CITY OF ALBUQUERQUE

August 14, 2018

RE: Tierra Serena (Glendesto) Subdivision
Revised Grading Plan Stamp Date: 8/9/18
Drainage Supplement Stamp Date: none
Hydrology File: B18D020

GLANDALE AVENUE NE  
STA. 14+00.00 TO STA. 24+85.59  
SCALE: HORIZ. 1" = 50'  
VERT. 1" = 10'

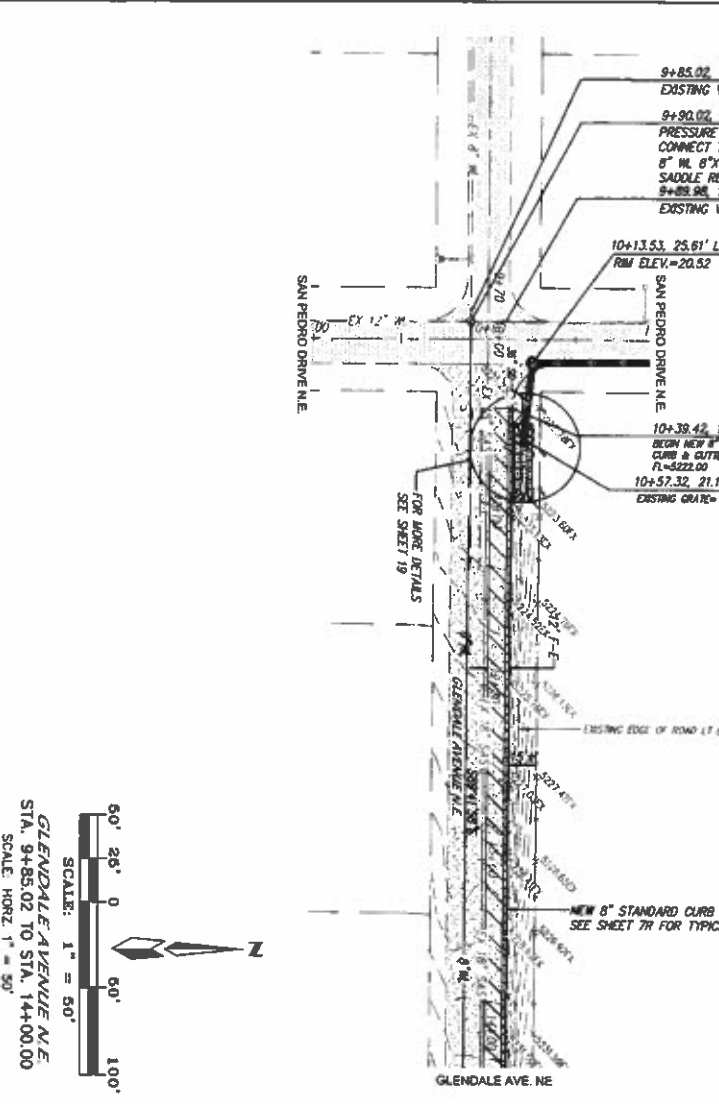
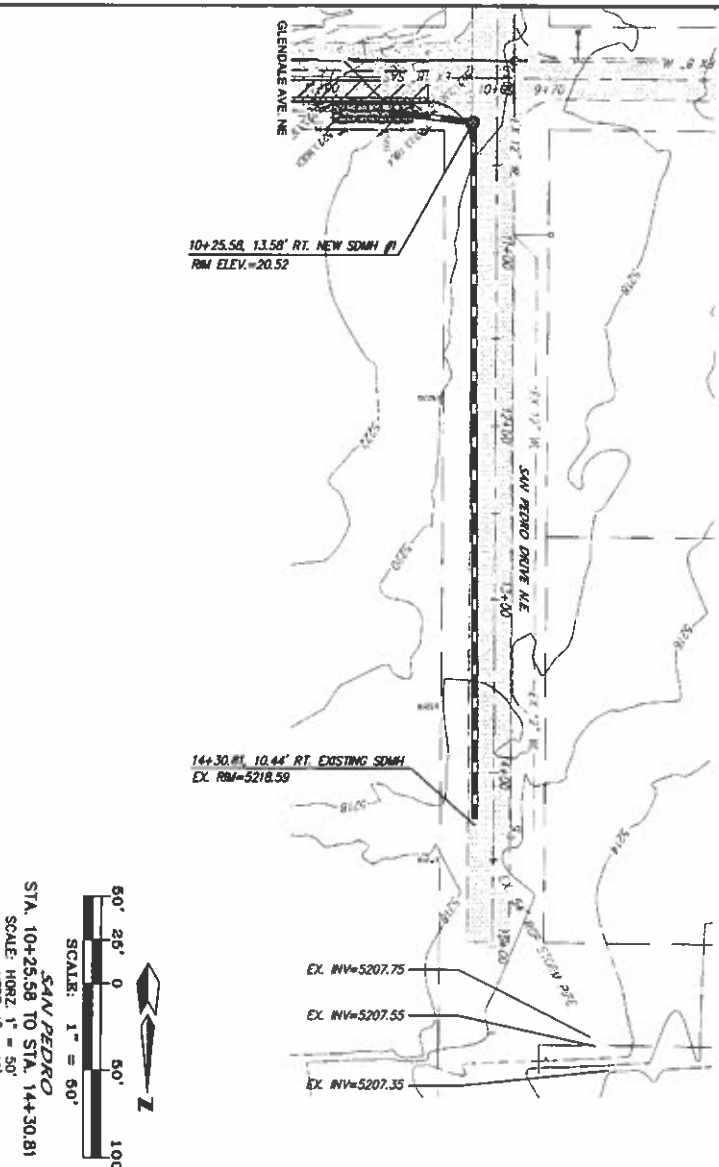
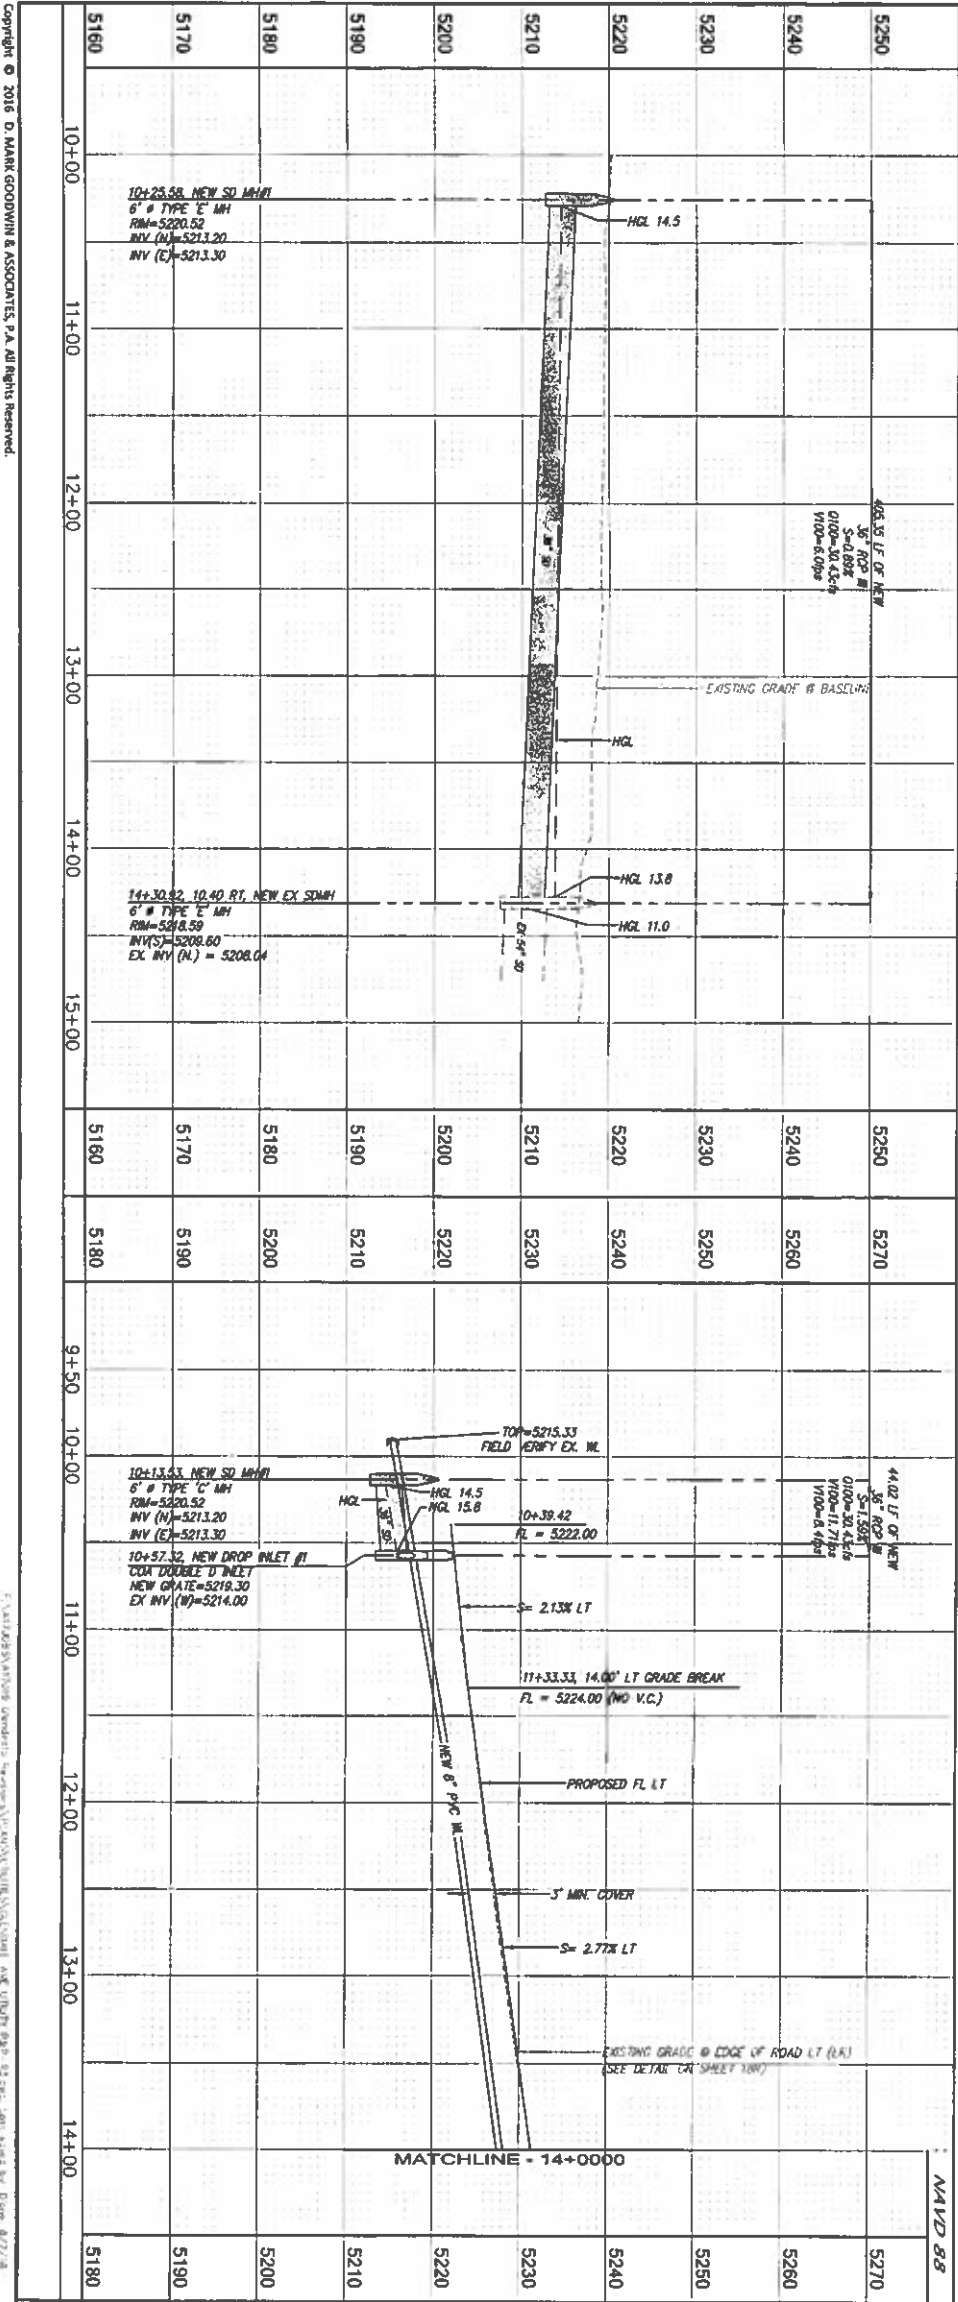
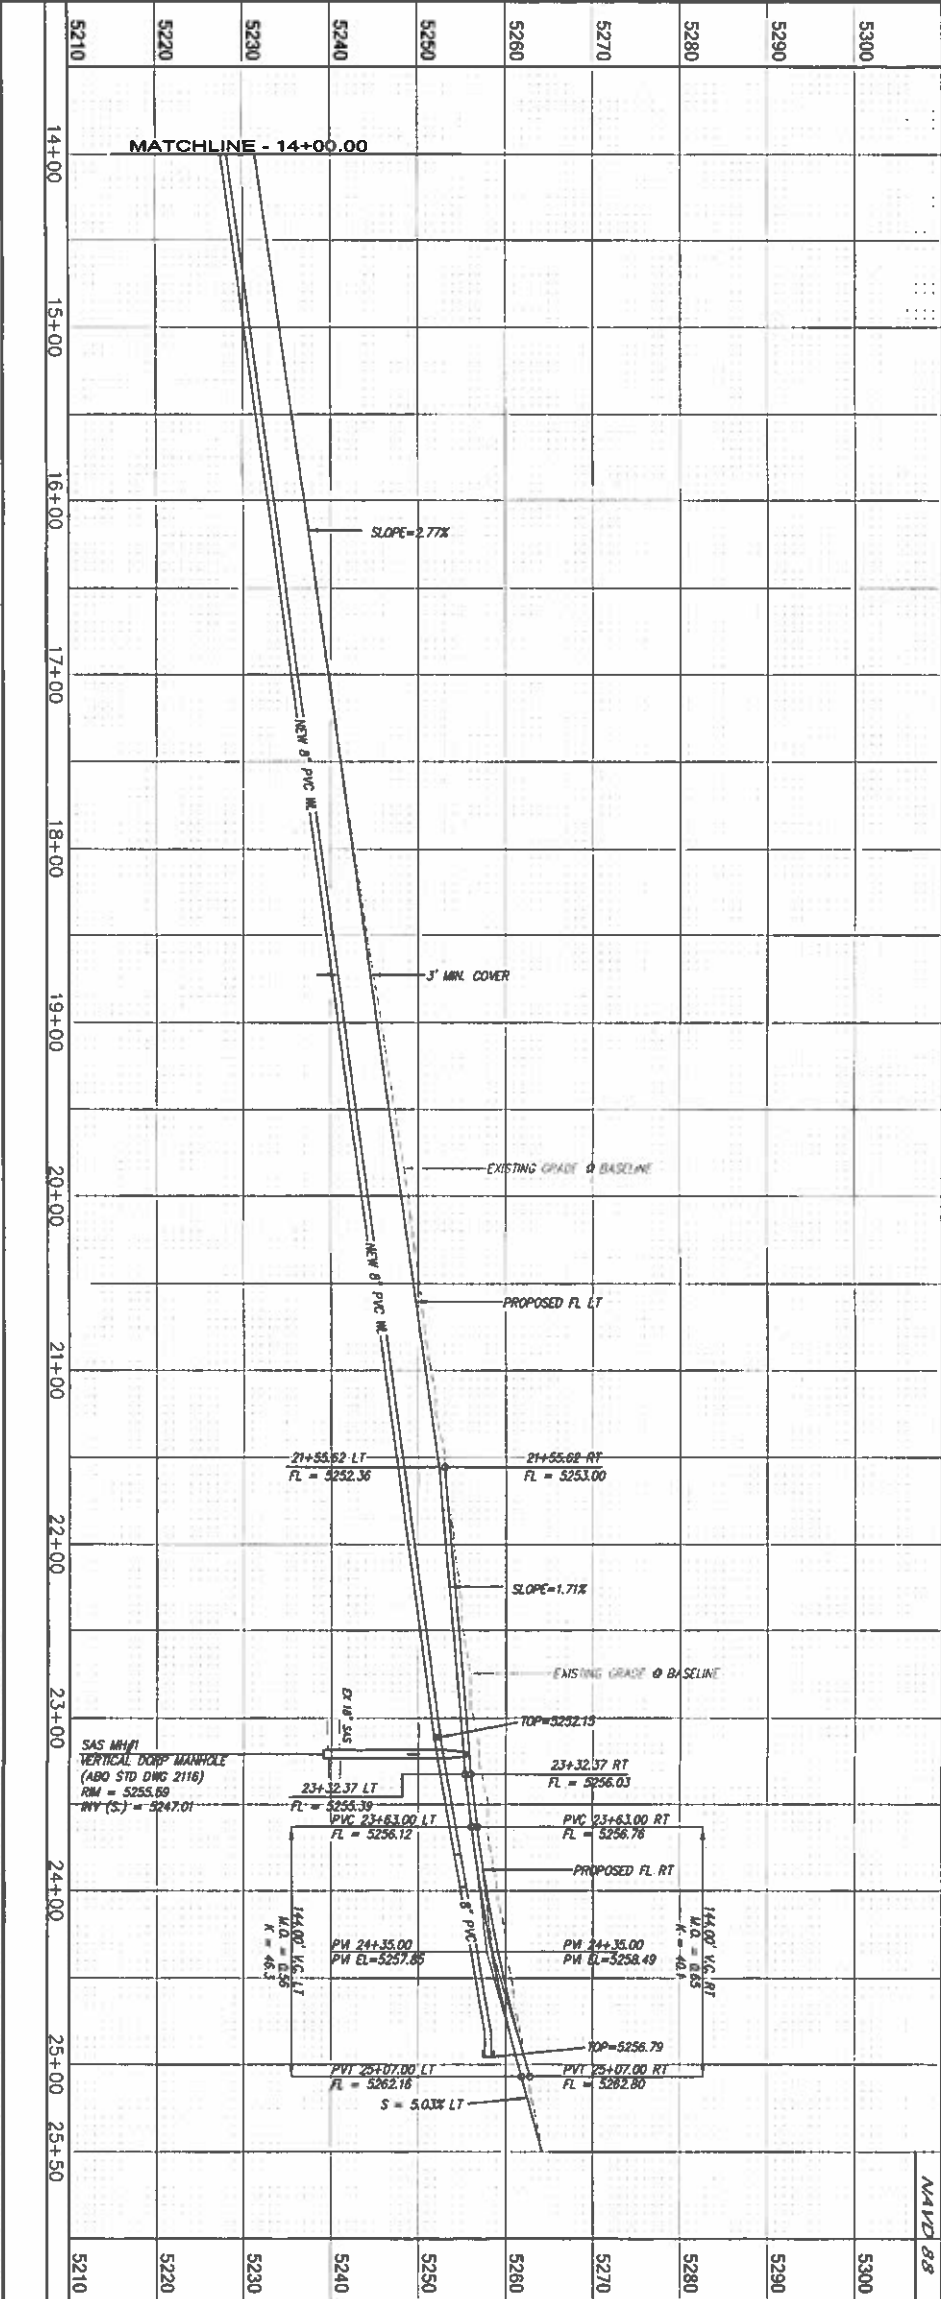
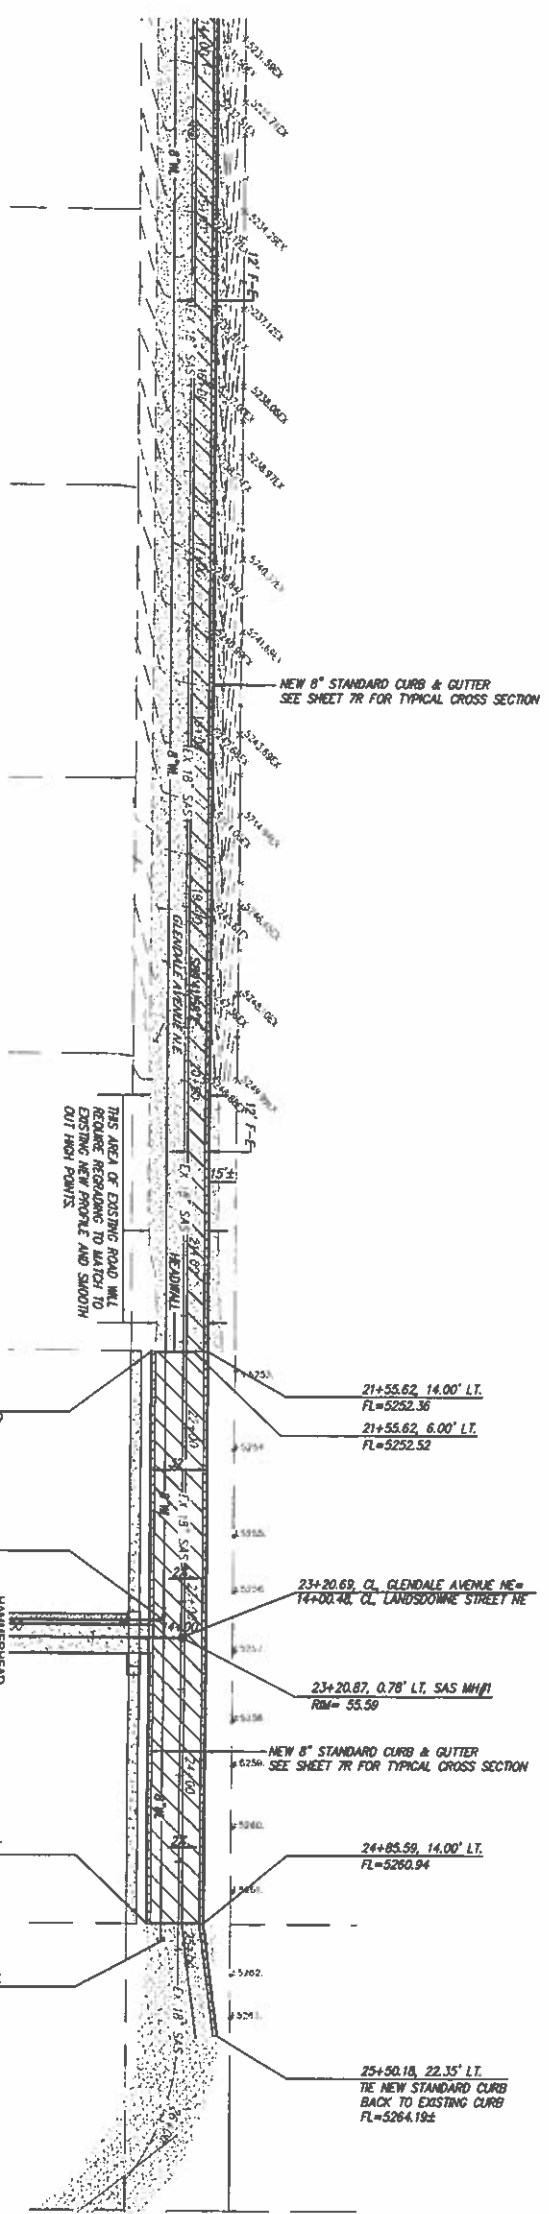
1. 100% interception of the 100-yr flow is required. No bypass will be allowed.
2. Provide HGL calculations and stormdrain profile for the revised stormdrain down the manhole at San Pedro/Glendale.
3. Provide street capacity calculations for the 10-yr storm. Demonstrate that it is contained on the asphalt section.
4. Date the drainage report supplement.
